Our Ref: 22/00616/LBC

APPLICATION NO: 22/00616/LBC

PROPOSAL: Proposed removal of existing render and replace with lime render to gable elevation, and repairs to the timber frame.

LOCATION: Jacobs Hall West 44 - 48 High Street Brightlingsea Colchester

48 High Street, Brightlingsea, Essex. CO7 0AQ.
 Digitally rectified photography of the exposed gable. 14 06 2021.

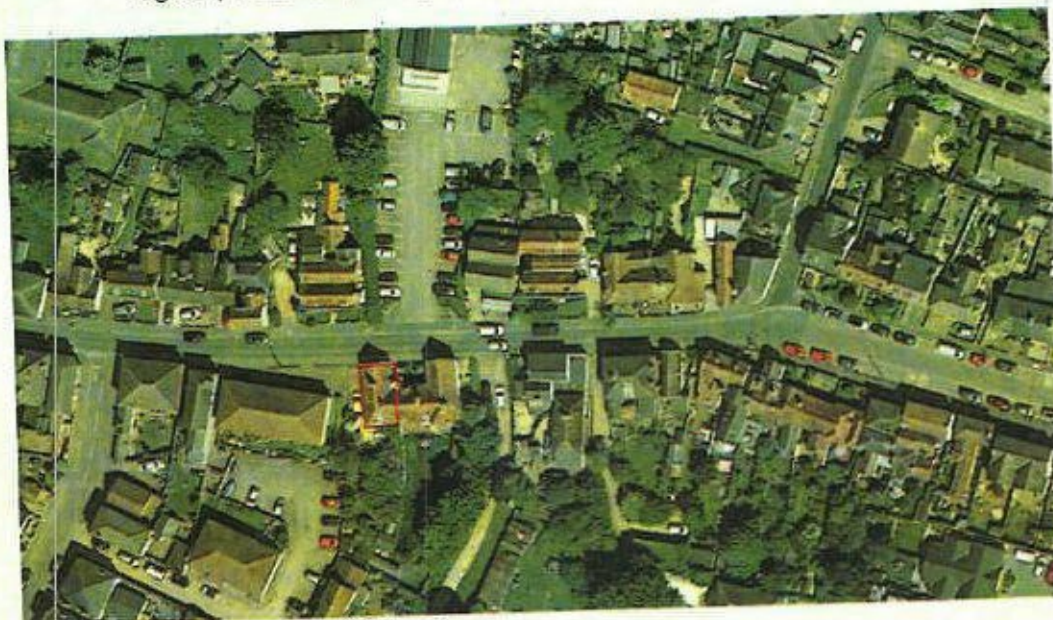
- Method Statement to remove all the modern applied render to that gable elevation;
- A Method Statement for the principles of the timber repair;
- A timber frame survey (the drawing submitted shows the timbers are far too uniform);
- Whilst exposed a scheme of photogrammetry building recording;
- A detailed schedule of repair to the timber frame and panels; and,
- Details of render to be reapplied and where.
